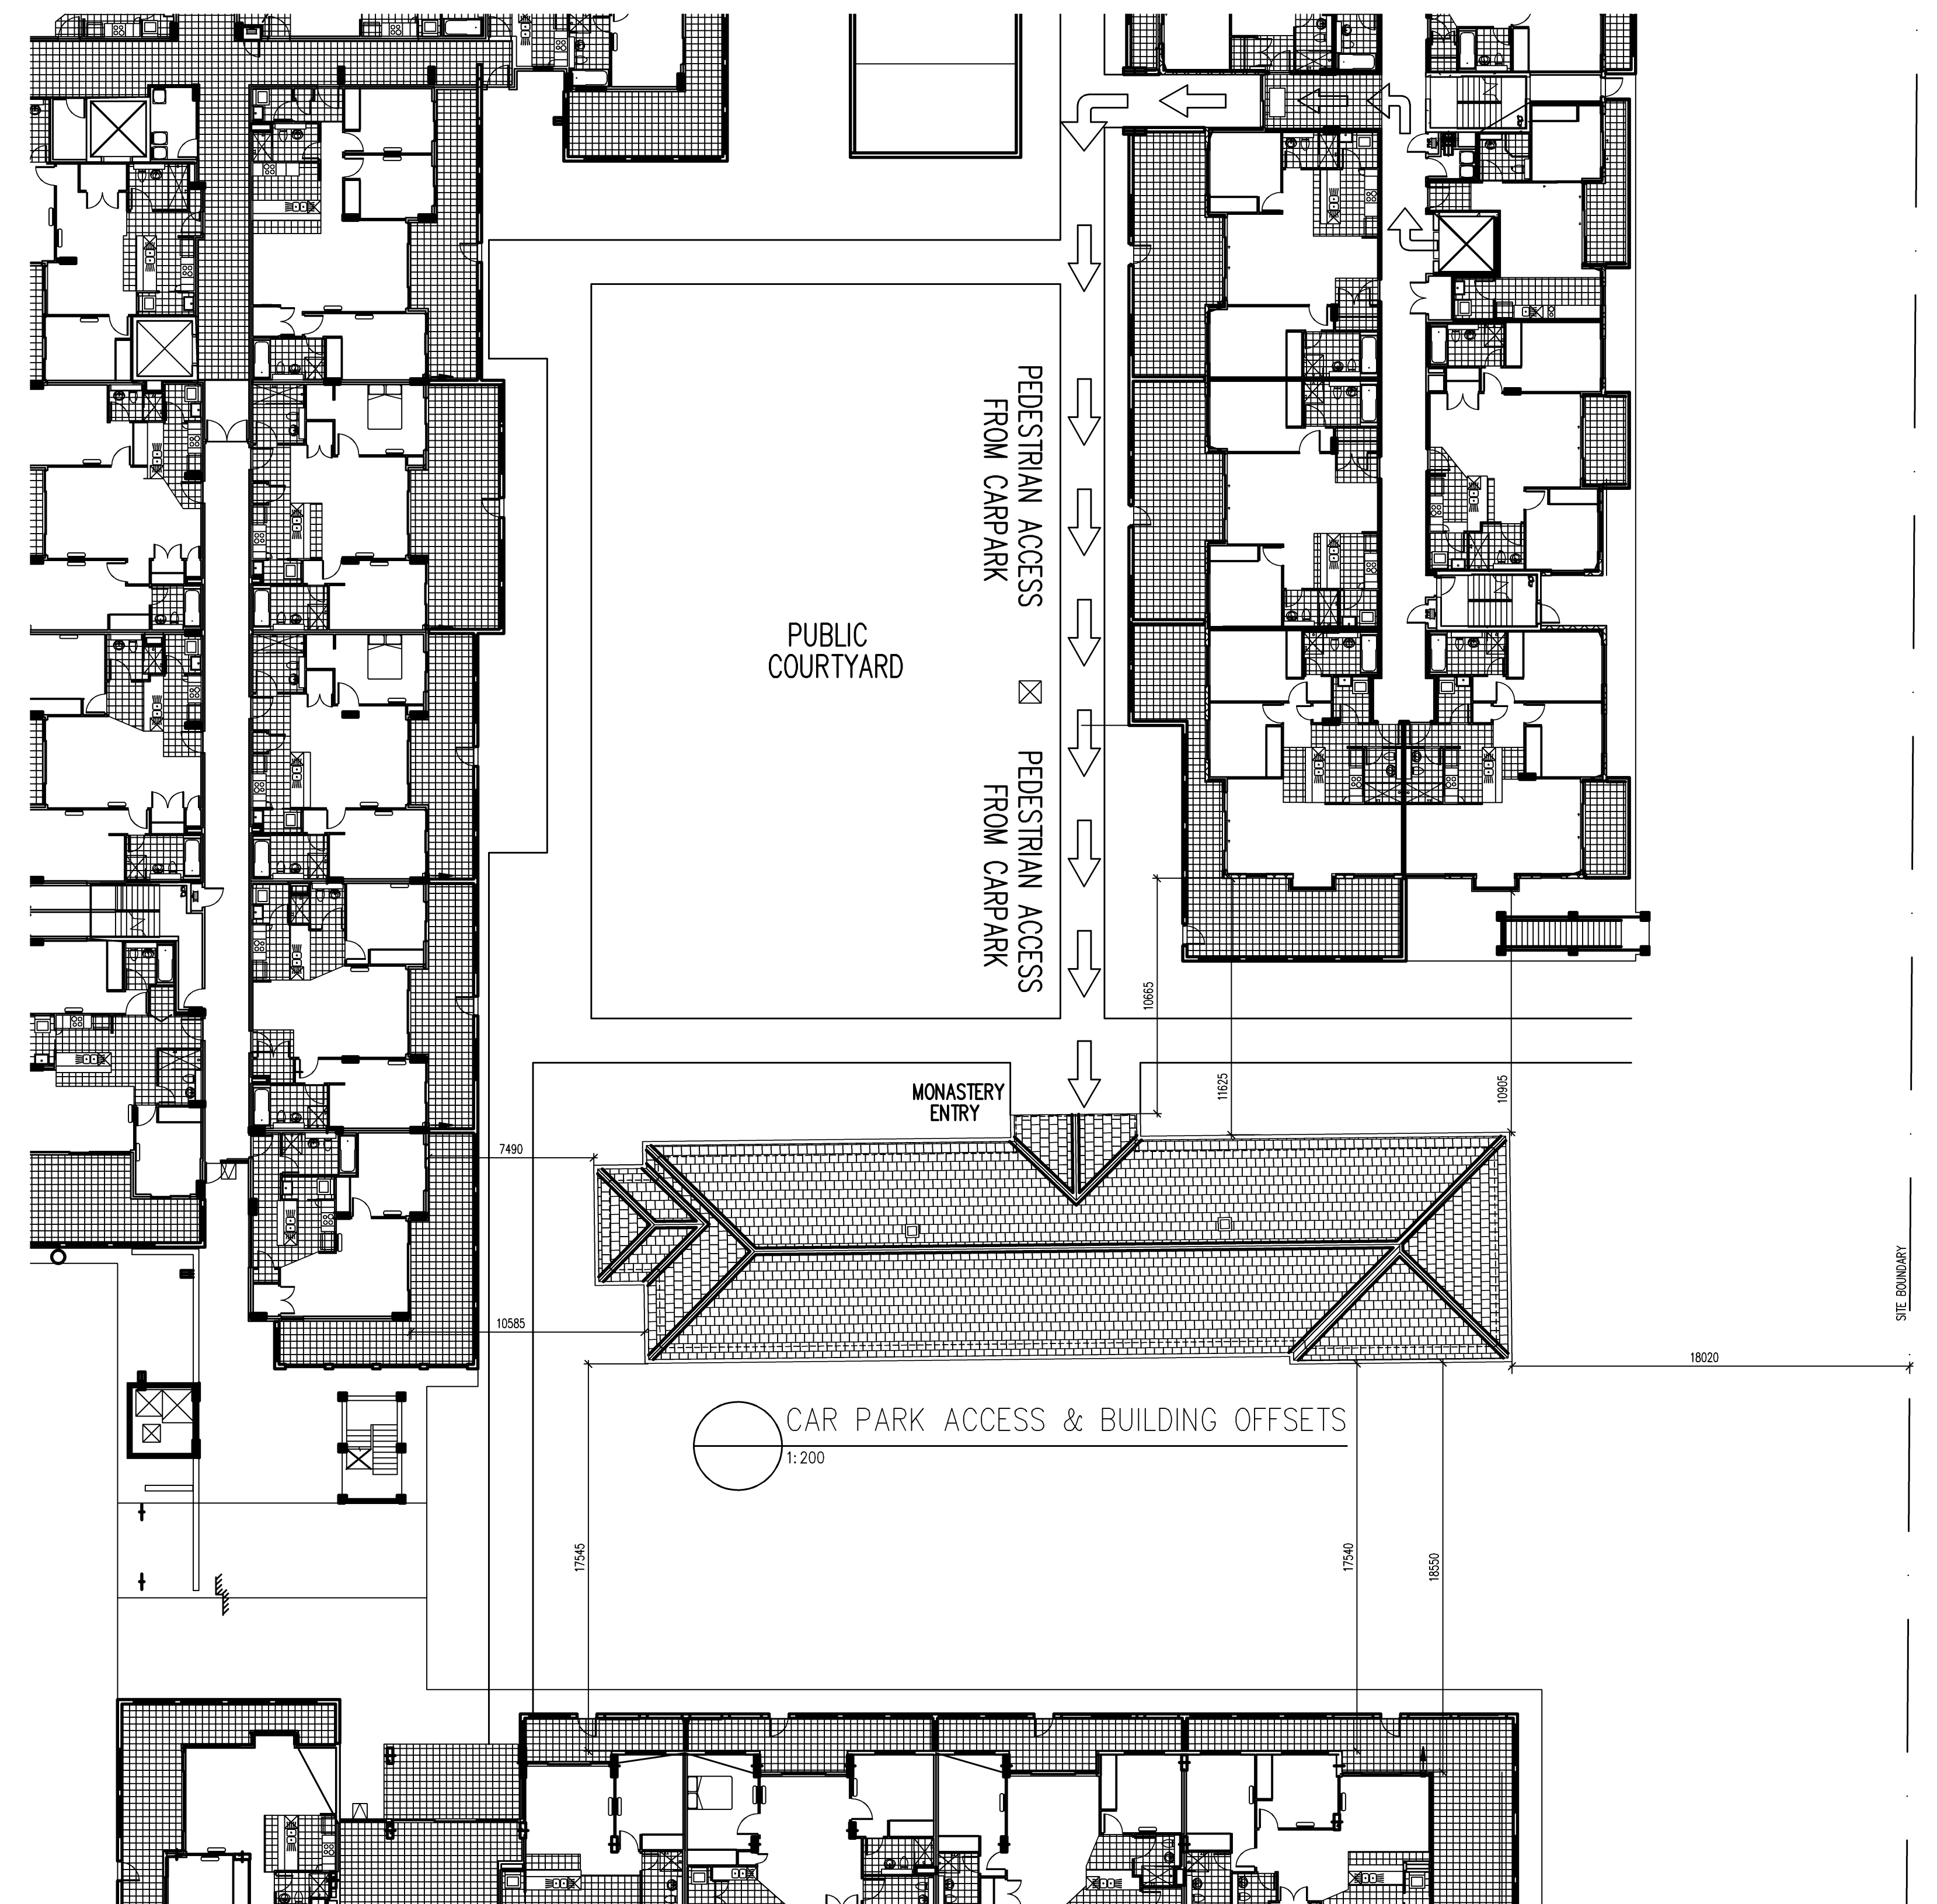
3 out of 4 proposed units fail to provide balcony/private open space for the respective units. This is unacceptable amenity for 2 bedroom units.

Unit sizes are not indicated on plan (to determine whether the units are in fact, undersized with the SEPP65/RFDC requirements).
